**Subject:** RE: A/110/20/RES Land South of Water Lane Angmering Ap/17/OUT for the Bridge over the Black Ditch providing access to the approved development.

With regard to Planning Application A/110/20/RES further information has become available since I submitted my representations.

The EYA 2018 report contains 24 maps titled Case A, which is pre-development and Case-B, which is post development.

Figure 3.24: Case-B: Pre-development, level map 0.1% AEP

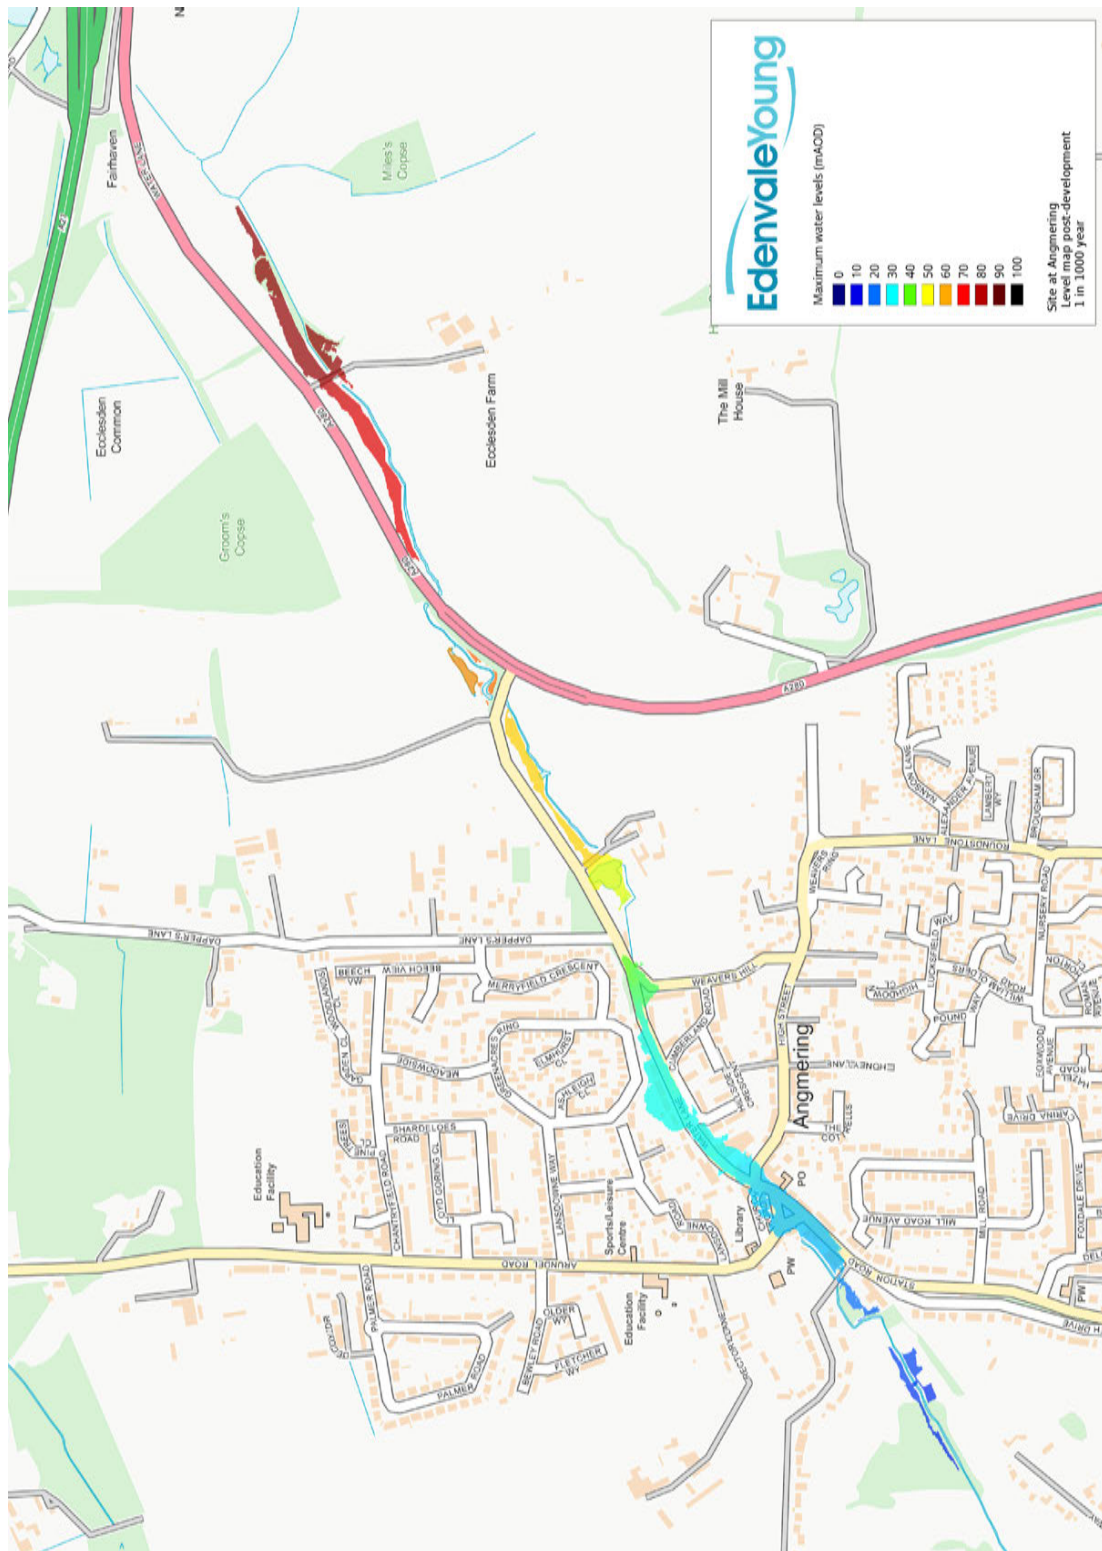
For example, the key to both the Case-A and Case-B level maps that describes 'Maximum water levels (mAOD)', and upstream of the Ecclesden Farm access the level is colour coded medium red corresponding to 80 metres AOD on the key, when we know that the top of Highdown is 81 metres AOD.

- The case B depth maps numbered 3.7 to 3.12 are headed 'Pre-development' when it seems they should be 'Post-development'.
- The case B level maps numbered 3.19 to 3.24 are also headed 'Pre-development' when it seems they should be 'Post-development'.
